**KIRKLEES METROPOLITAN COUNCIL
INVESTMENT & REGENERATION SERVICE**

DELEGATED DECISION TO DETERMINE PLANNING APPLICATIONS

Reference No:	2024/62/90285/E
Site Address:	48, Roberttown Lane, Roberttown, Liversedge, WF15 7LY
Description:	Erection of two storey rear extension
Recommending Officer:	Jennifer Booth

DECISION - REFUSED

10-PL-006 :dwg no.
PROPOSED FIRST FLOOR PLAN 1:50@A3
 48 ROBERTTOWN LANE
 LEEDS

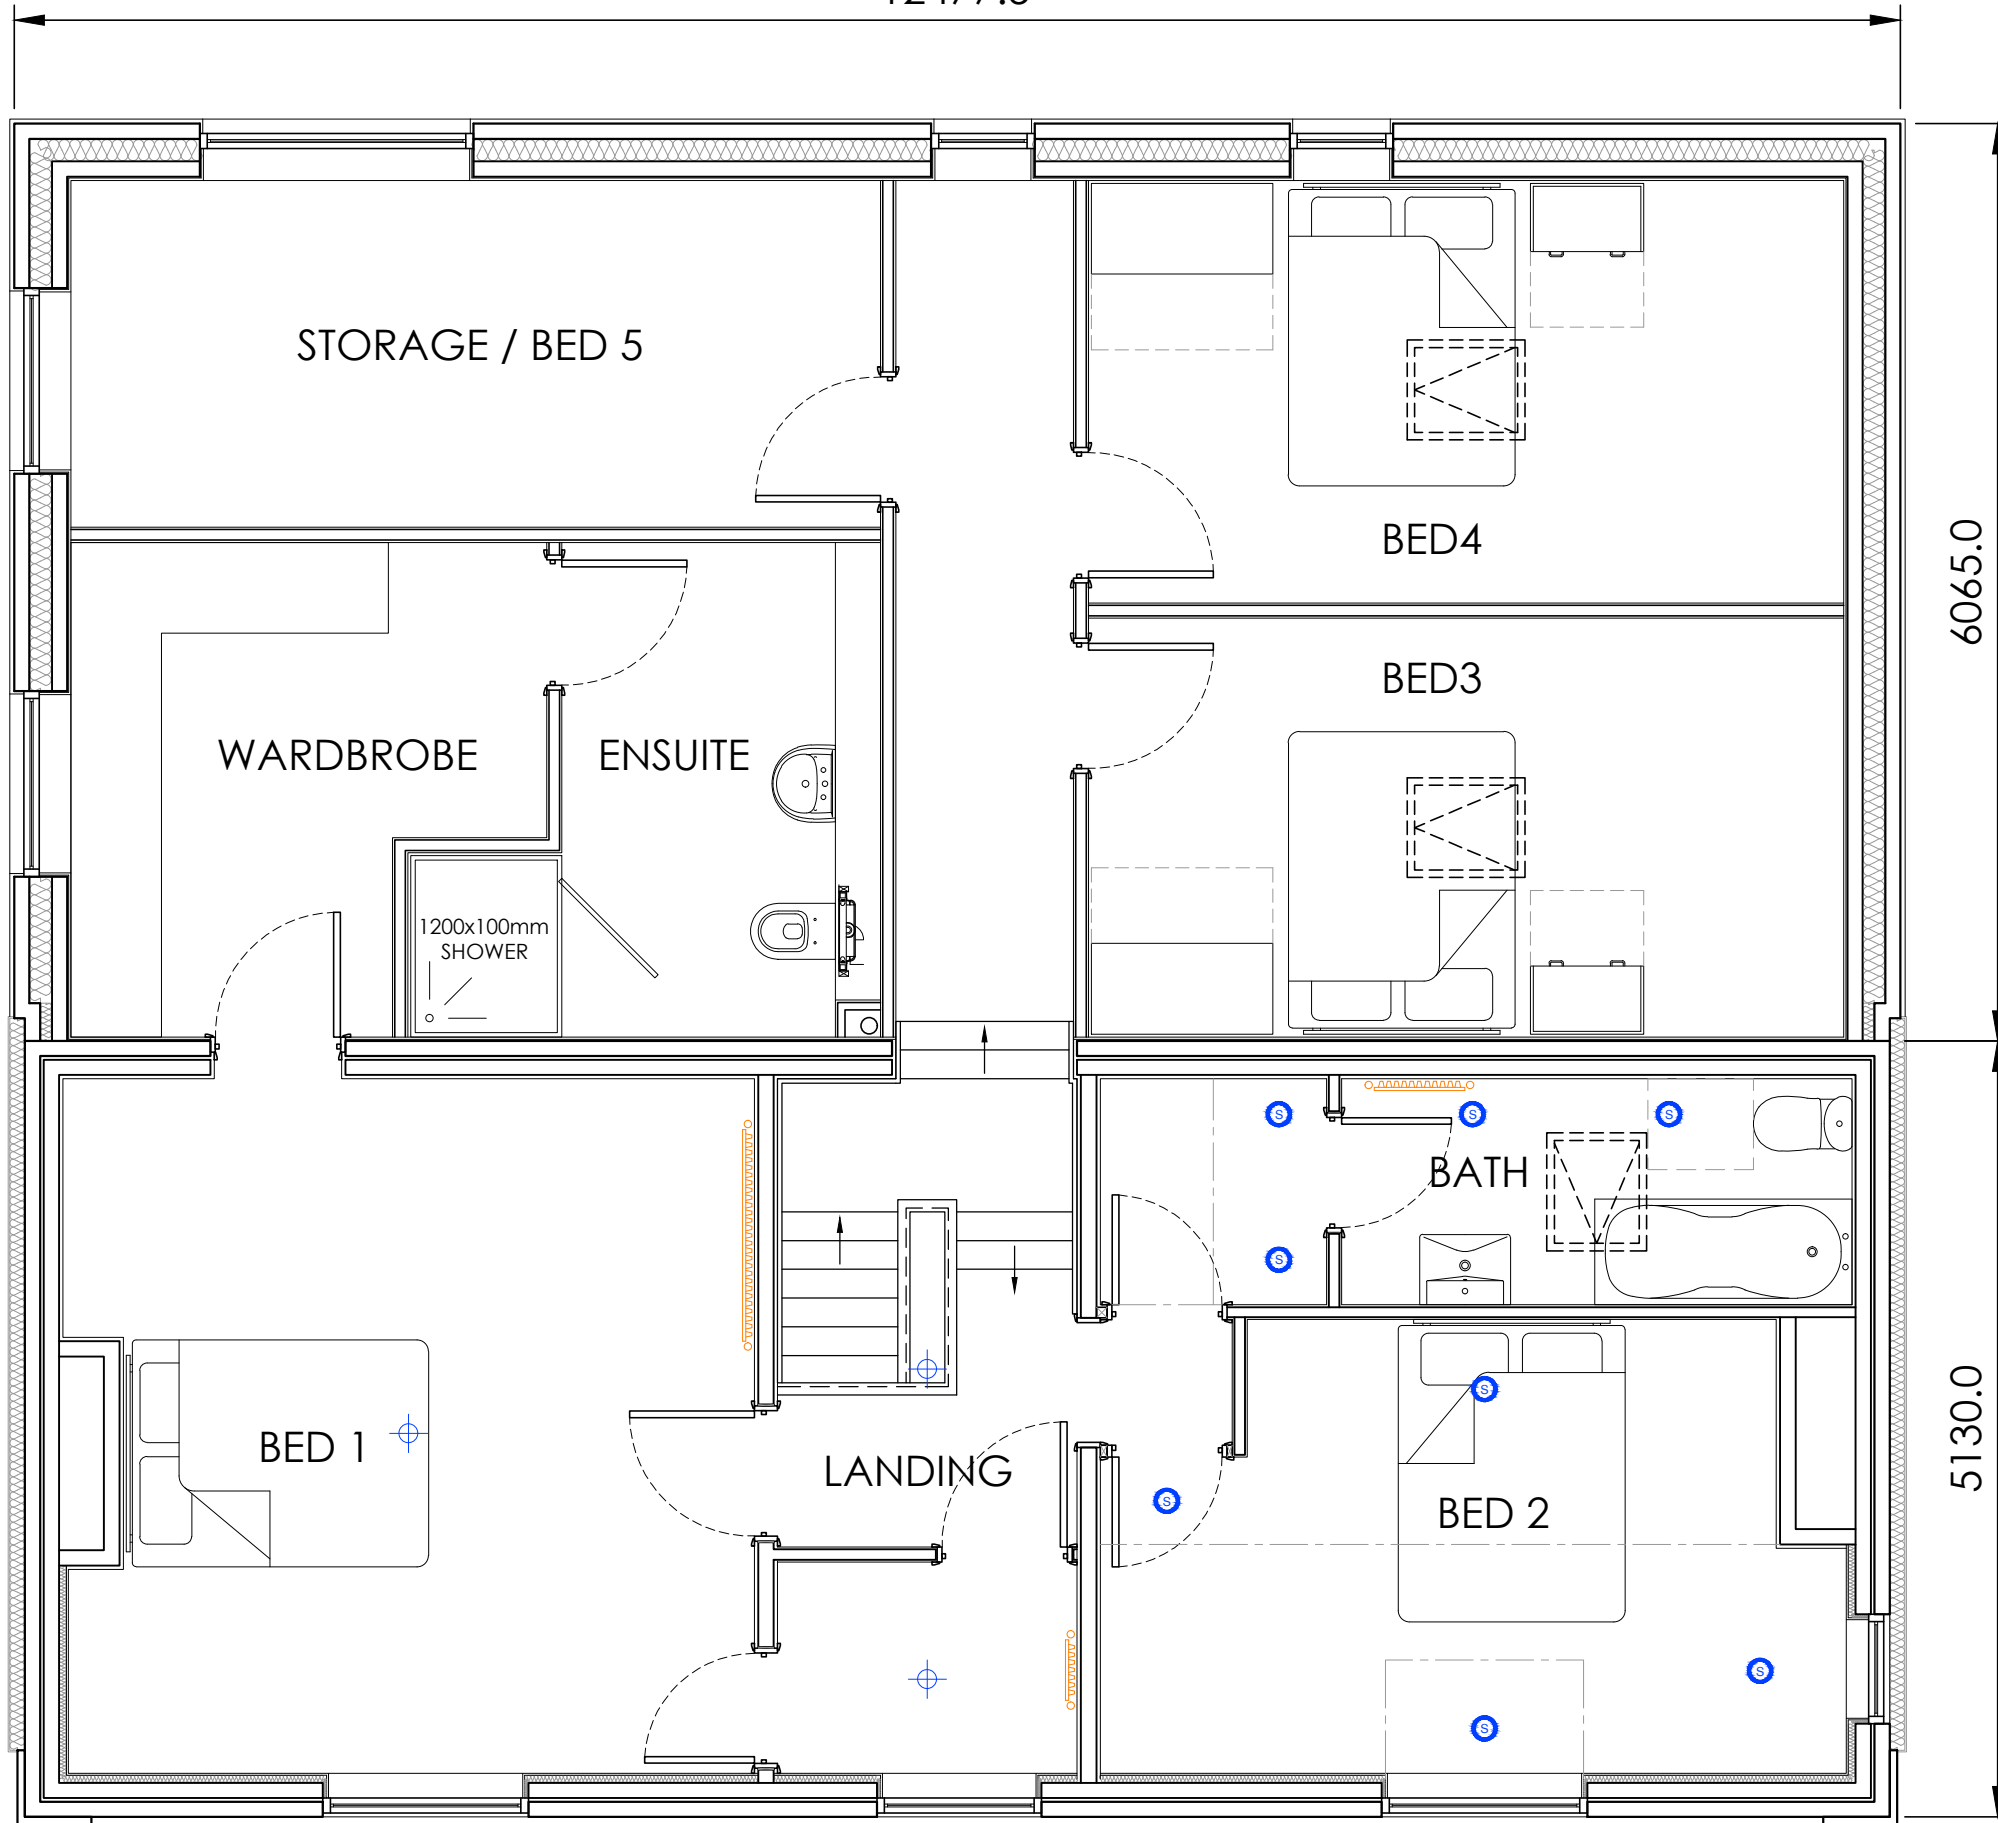
The neighbour to the rear occupies a position some 21m from the site. With the projection of the extension proposed at 6m with accommodation across three floors together with the neighbour occupying a slightly lower land level and having a single storey nature, the extension would result in an overbearing impact with potential for loss of privacy.

**10-PL-007 :dwg no.**  
**PROPOSED ELEVATIONS 1:100@A3**  
**48 ROBERTTOWN LANE**  
**LEEDS**

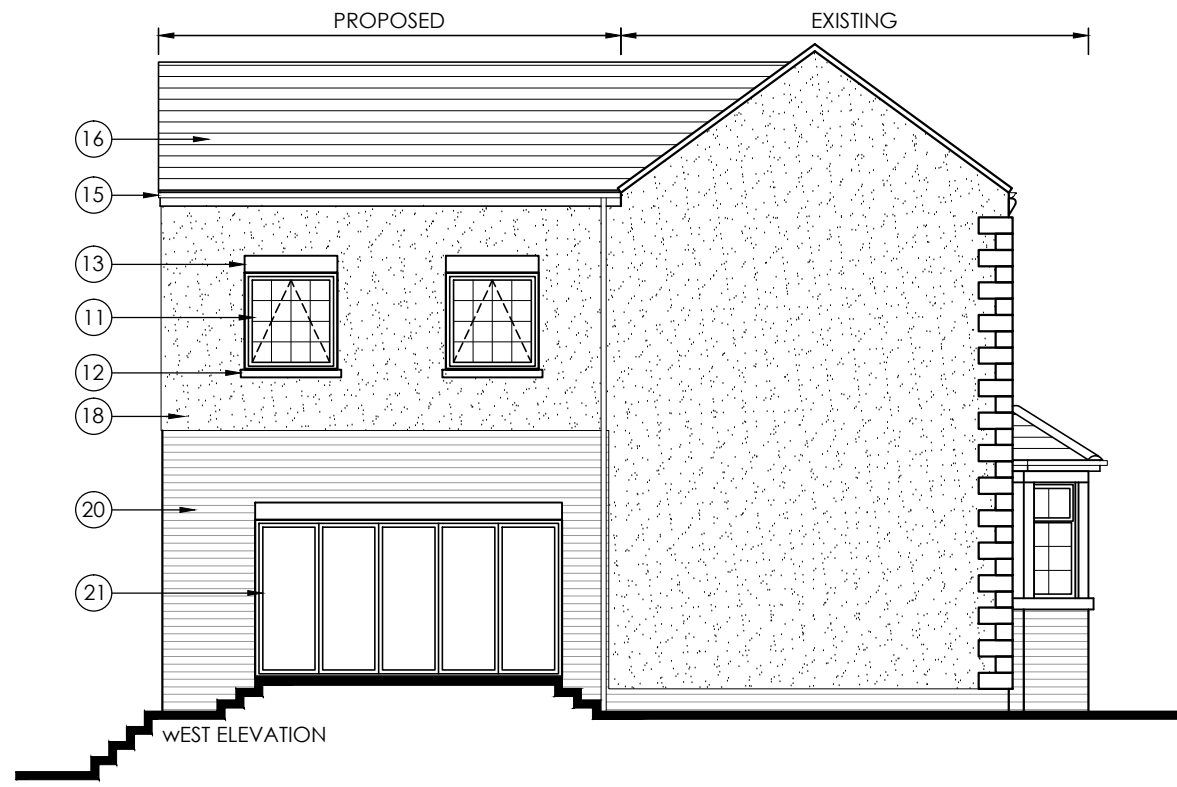
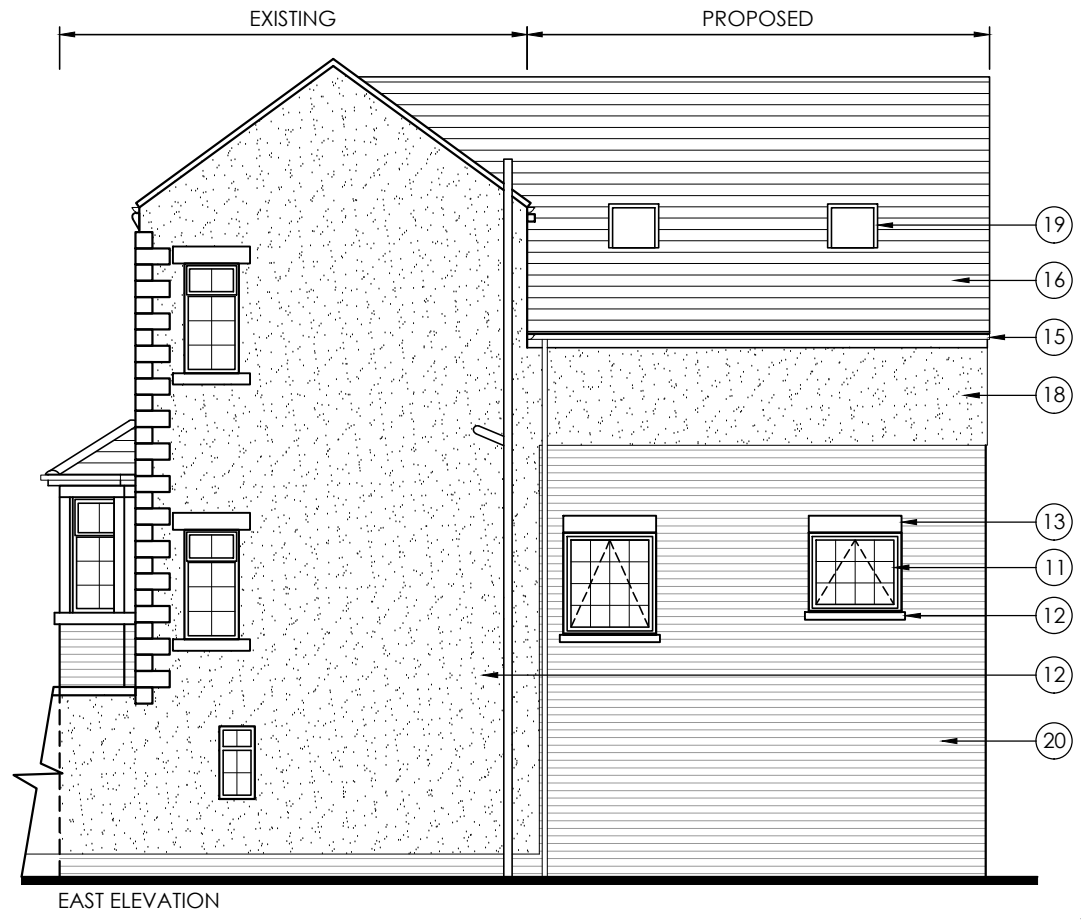
When assessing whether extensions are disproportionate, the scale and design need to be considered. The location of the host property is semi-rural with only the property at the rear in the immediate vicinity. The scale of the rear extension is the same size as the house itself and as such would not be considered to be acceptable in terms of scale. Due to the design and resulting mass, the main house would not remain the dominant element of the site, the works proposed would represent a disproportionate addition to the dwelling and would therefore represent inappropriate development in the Green Belt given its proposed scale contrary to Local Plan policy as well as the NPPF.

It is noted that the proposed plans indicate that the extension would be constructed using a combination of stone and render, which would match the main house. The design itself is a little irregular with the asymmetrical shape although this would not be considered in itself to be justification for refusing the scheme. However, the size of the extension would be significant with a projection almost equal to the depth of the house. The scale would not be proportionate to the main house and as such is not considered to be acceptable in terms of its scale detracting from the original host building as well as the area. The proposals are therefore not considered to be acceptable in terms of visual amenity or Local Plan Policy LP24.

The proposed extension by reason of the projection, height and overall scale would form a disproportionate addition and as such would constitute inappropriate development in the green belt. To permit the proposals would be contrary to Policy LP57 of the Kirklees Local Plan and advice within Chapter 13 of the National Planning Policy Framework.

The proposed extension by reason of the design, projection and scale would be out of proportion with the main house which would be detrimental to the character of the dwelling. To permit the proposals would be contrary to Policy LP24 of the Kirklees Local Plan, KDP1 & KDP2 of the House Extensions & Alterations SPD and Chapter 12 of the National Planning Policy Framework.

The proposed extension by reason of the projection and height would result in an overbearing and oppressive impact on the bungalow to the rear with potential for overlooking. To permit the proposals would be contrary to Policy LP24 of the Kirklees Local Plan, KDP3& KDP6 of the House Extensions & Alterations SPD and Chapter 12 of the National Planning Policy Framework.
